REF: N147950

DATE: 27 February 2020

**RE: MEADOWBANK EDUCATION AND EMPLOYMENT PRECINCT SCHOOLS PROJECT – SSD
18_9343 RESPONSE TO TRANSPORT RELATED SUBMISSIONS**

Response to Submissions

BASE DRAWING BASED ON THE FOLLOWING DRAWING
DRAWING: MSP-EN-CV-00511
AUTHOR: ENSTRUCT
REVISION: 06
DATE: 8 OCTOBER 2019

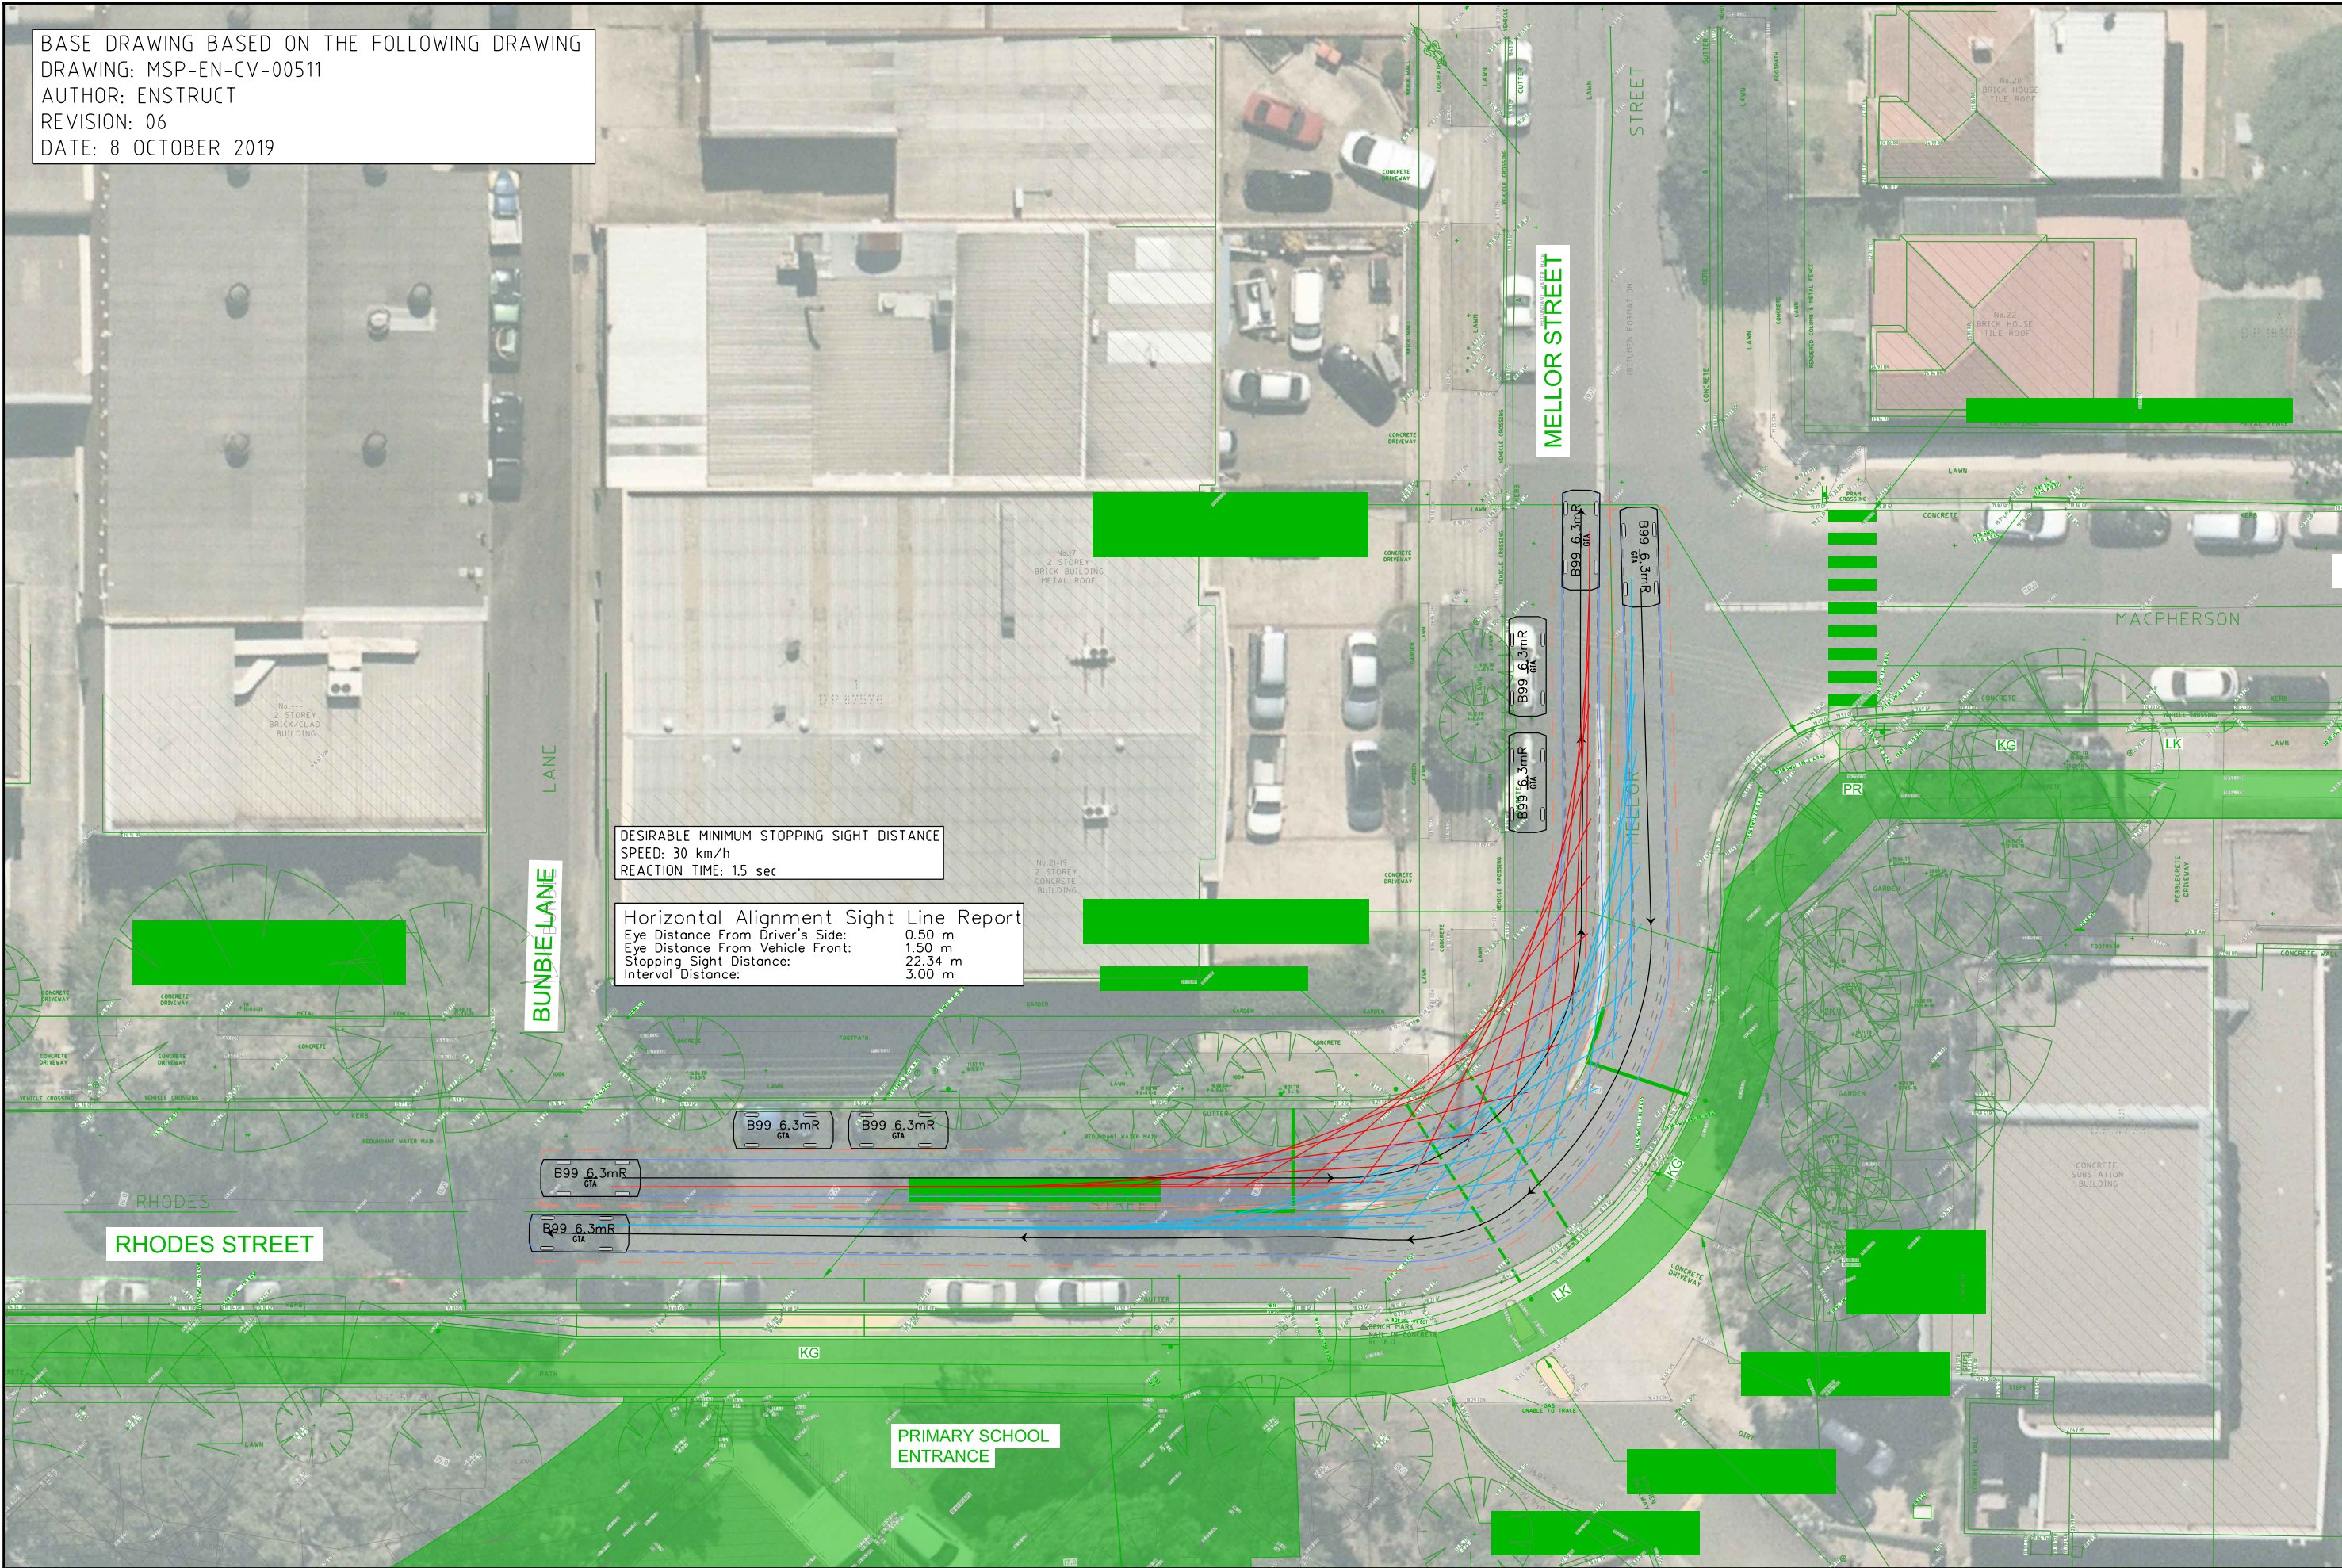
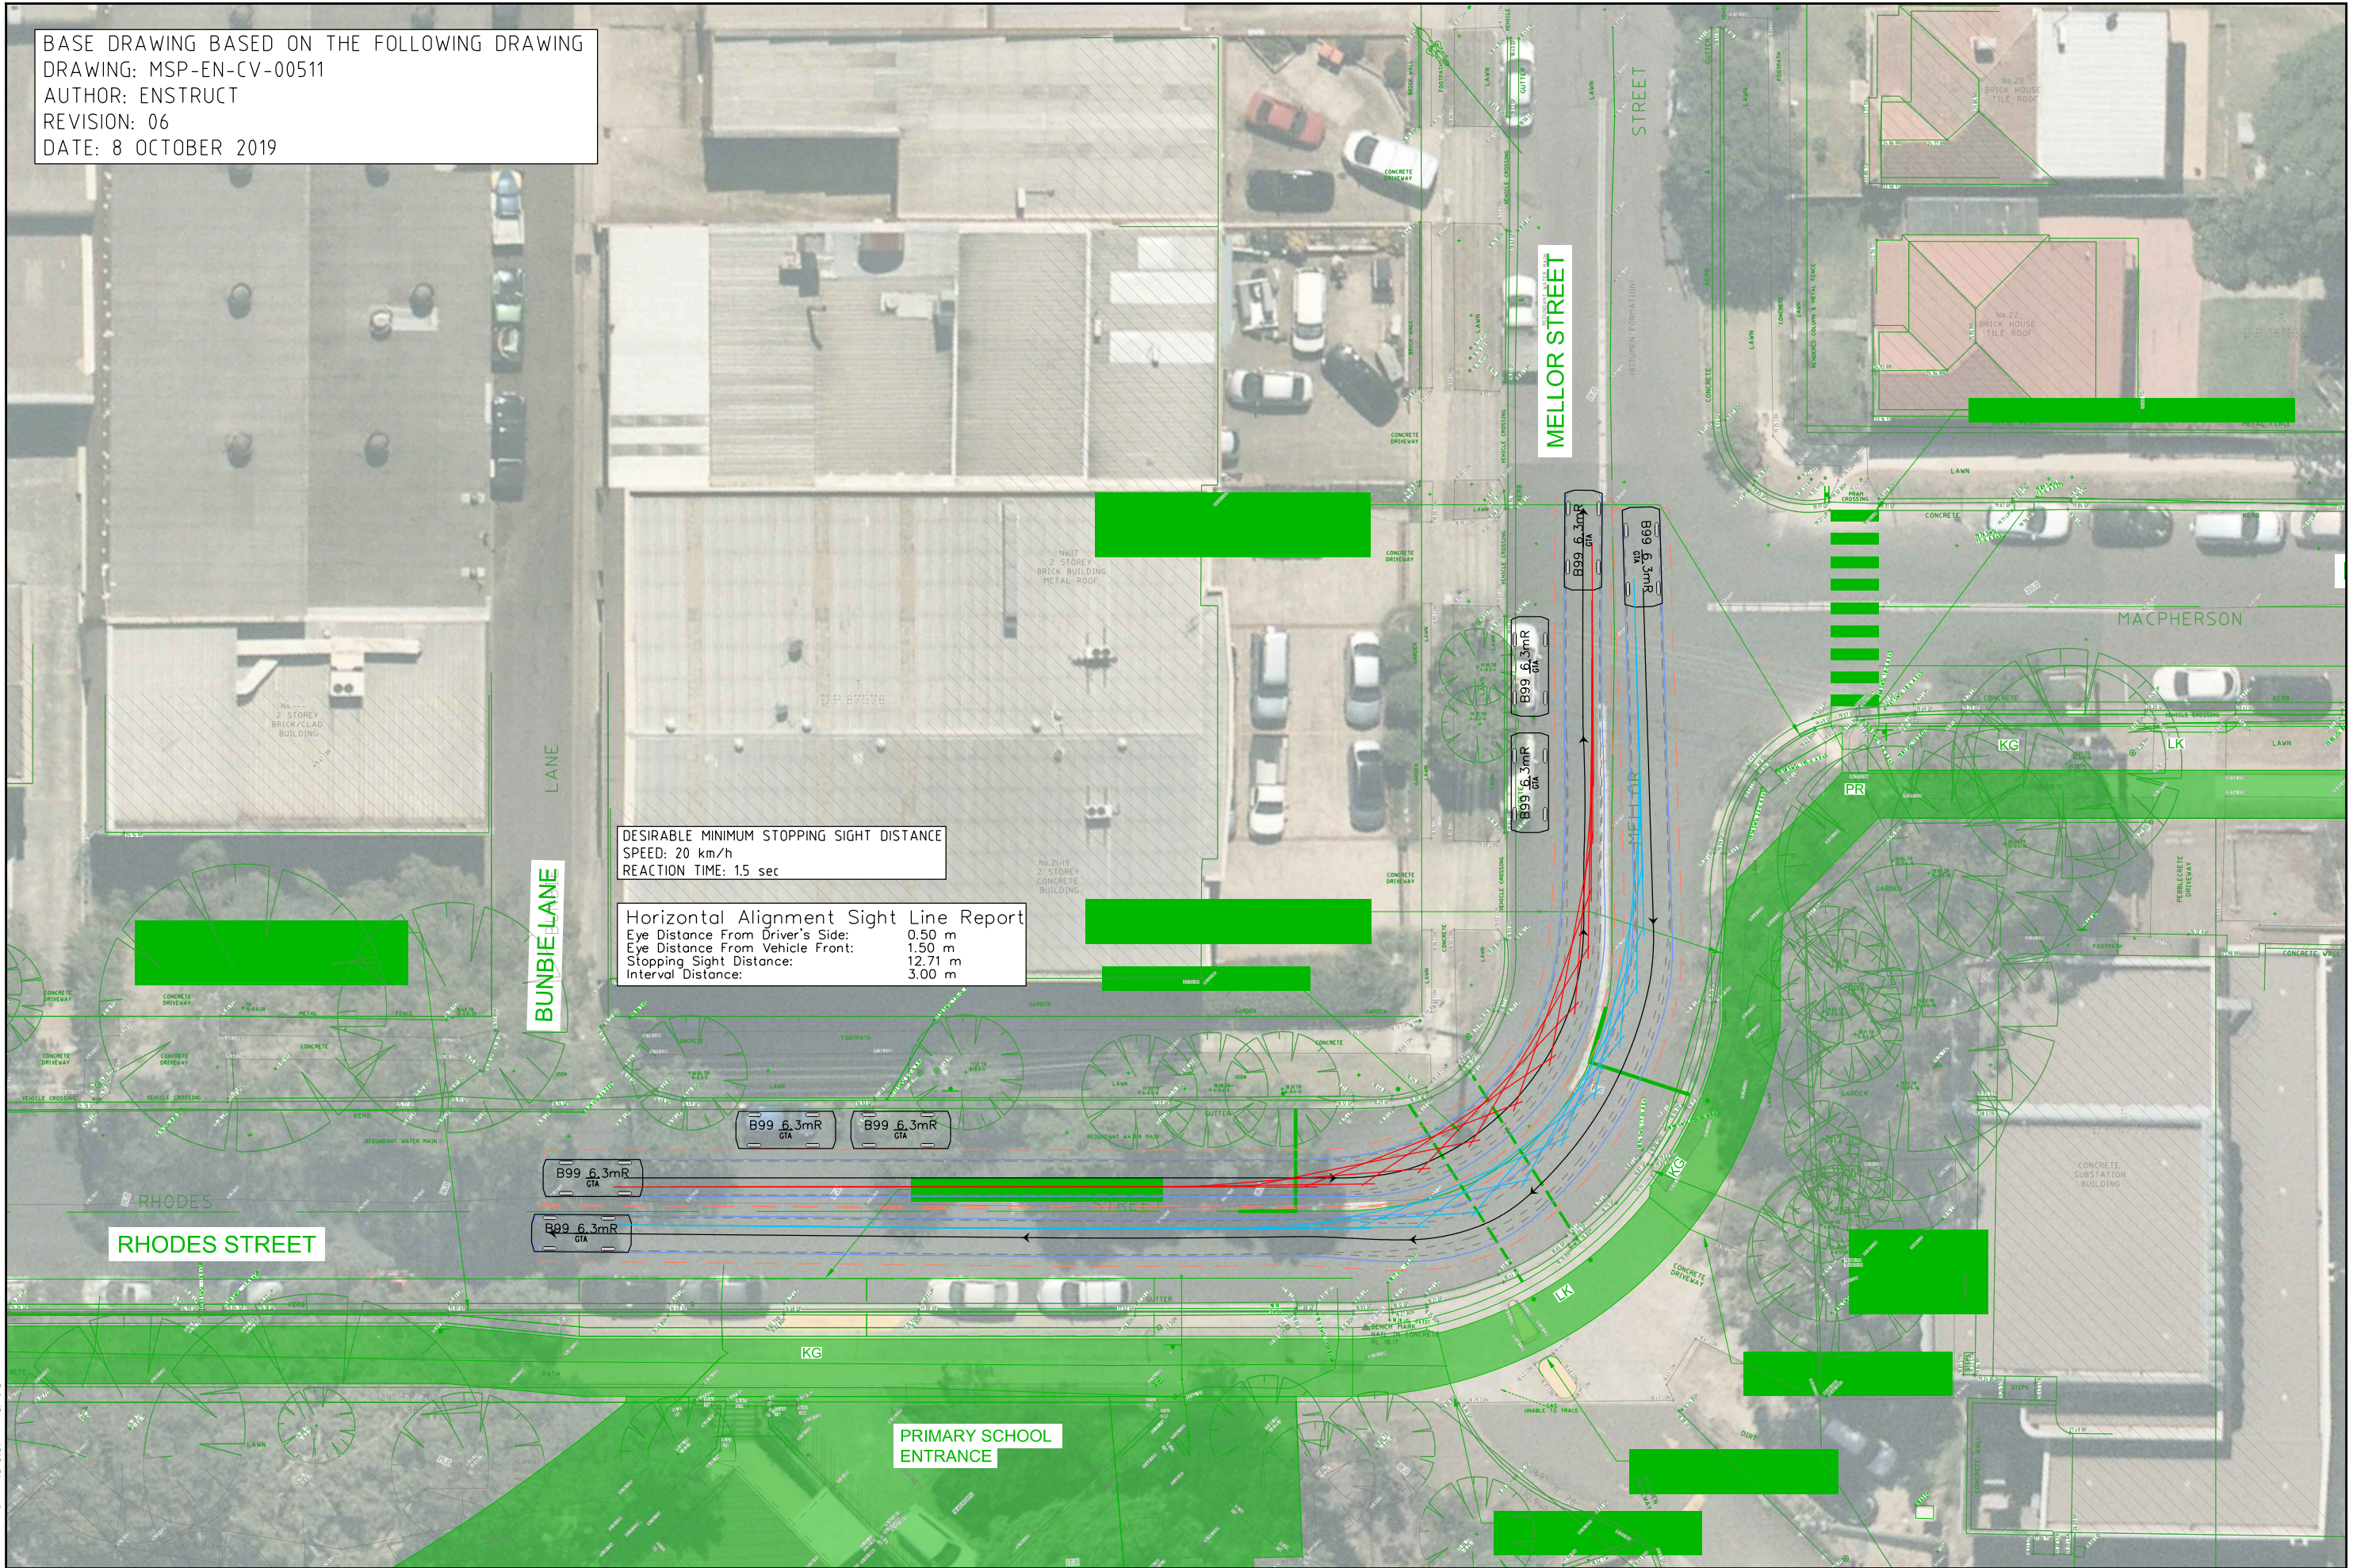
Comment 4: The school catchment analysis prepared by Frank Turquoise Group indicates a potential of 27.8% of staff and 52.6% of students live within an 800m catchment of the proposed school, which could potentially use buses to reach the school. 800m is considered to be within walking distance. Existing bus services primarily stop along Victoria Road. The current report provides no clear indication of how pedestrian accessibility and footpath requirements have been considered for access between Victoria Road bus stops and the school entrance.

Consideration should be given to implement measures to improve pedestrian facilities to ensure safe and efficient paths of travel for students, especially for those students needing to traverse the T9 railway line and Victoria Road.

A new pedestrian crossing is proposed on Macpherson Street improving pedestrian amenity to the north and connecting with the bus stops along Victoria Road. Pedestrian (zebra) crossing reduced warrants for sites used predominantly by children are as follows:

Based on the above, the proposed pedestrian (zebra) crossing on Macpherson Street would meet TfNSW warrants.
